The Old Vinyl Factory, Hayes – Phase 3B ‘The Assembly Buildings’ Planning Statement

Prepared in support of application to discharge Condition 4
(Podium Access) of Planning Permission Ref. No.
59872/APP/2020/342.

Planning Statement

Title	Proposed 2nd Floor Plan		
Site	The Assembly Buildings, Hayes		
Drg.	WH199/21/P/25.03d		
Date	Nov 2021	Rev	-
Drawn	JM	Scale	1:200 @ A2

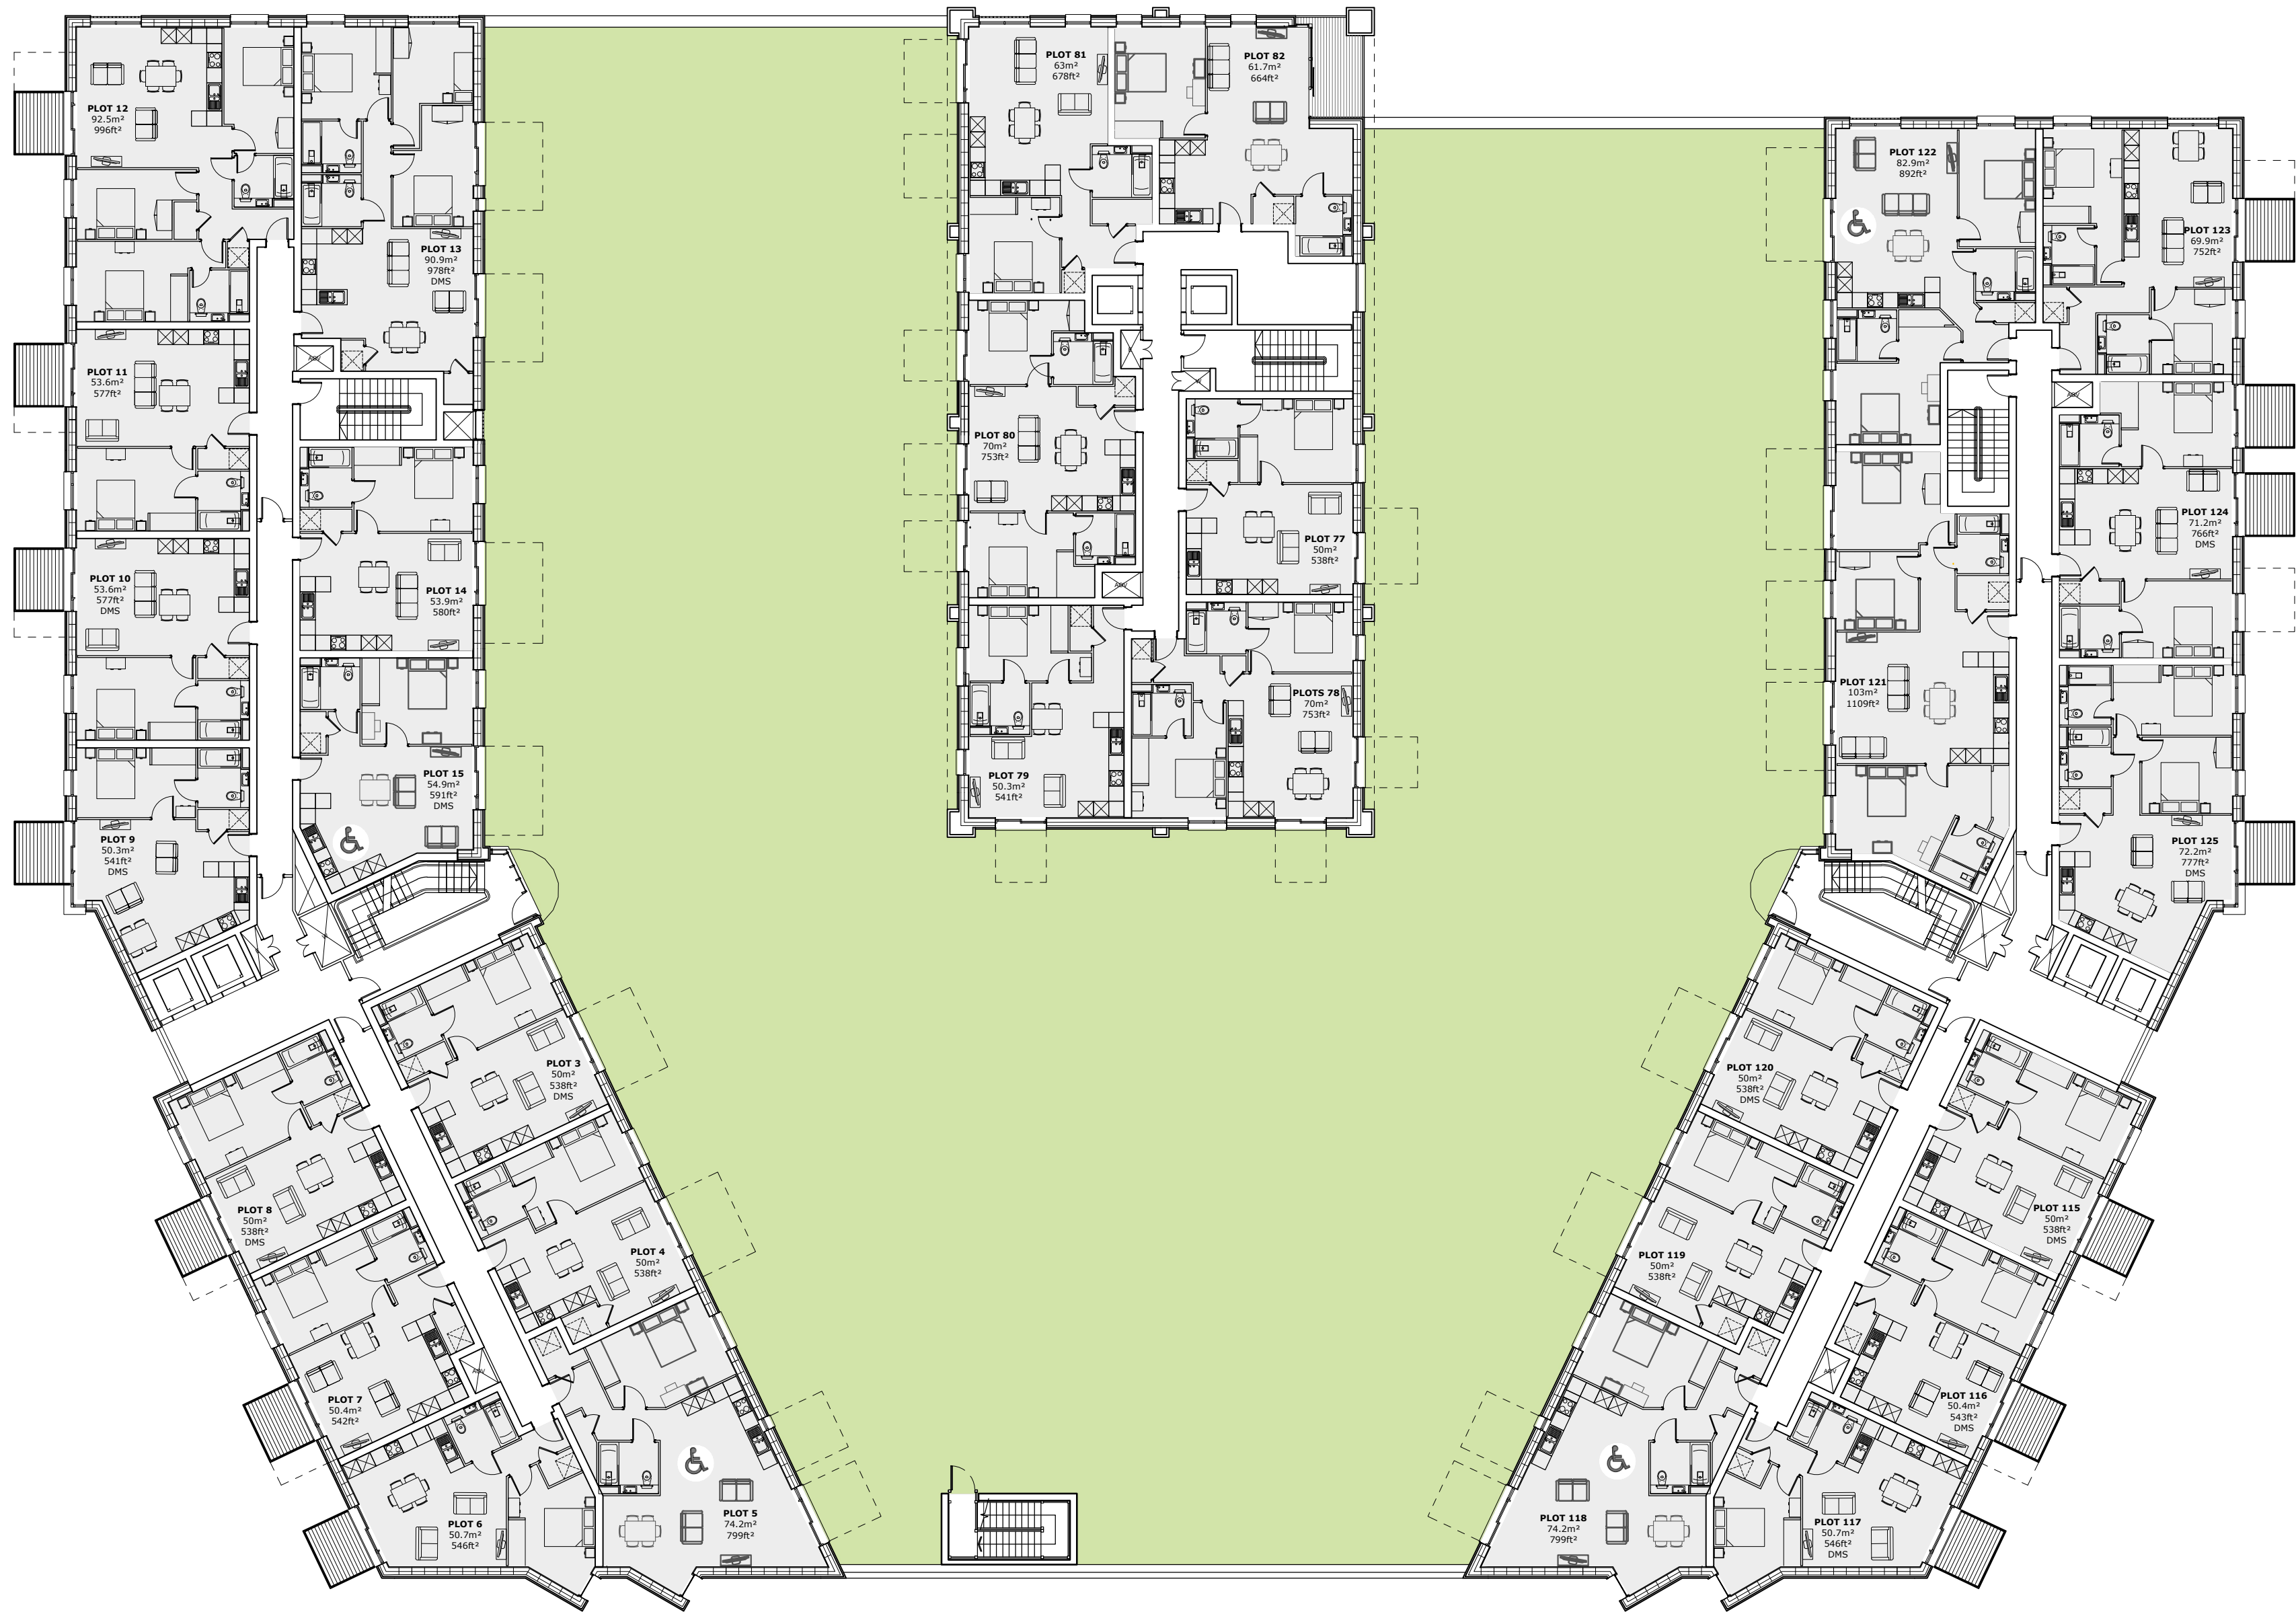
The proposed stairs would also result in a loss of parking as they are located where a parking space is approved at first floor level (as shown on approved drawing number WH199/20/P/25.02a Rev A). In addition, the proposals would result in the loss of external amenity spaces on the podium (as shown on approved drawing number WH199/20/P/25.03a Rev A). The loss of parking and the loss of external amenity space are not considered to be acceptable.'

- 2.50. As a result of the inclusion of the additional stair case [2.8m x 5.3m] (15sqm footprint) this results in the loss of a very small area of amenity space on the podium in comparison to that proposed show in the approved plans. However, there is in fact a greater quantity of amenity space in comparison to that approved (Application Ref. No. 59872/APP/2018/1107) as a result of previously approved amendments.
- 2.51. Therefore, it is not the case that the inclusion of the stair case onto the podium will bring the required amenity space to less than that required in the reserved matters submission. This detailing of this change is also captured under the above mentioned NMA which has recently been submitted to amend the approved plans to include the stair case.
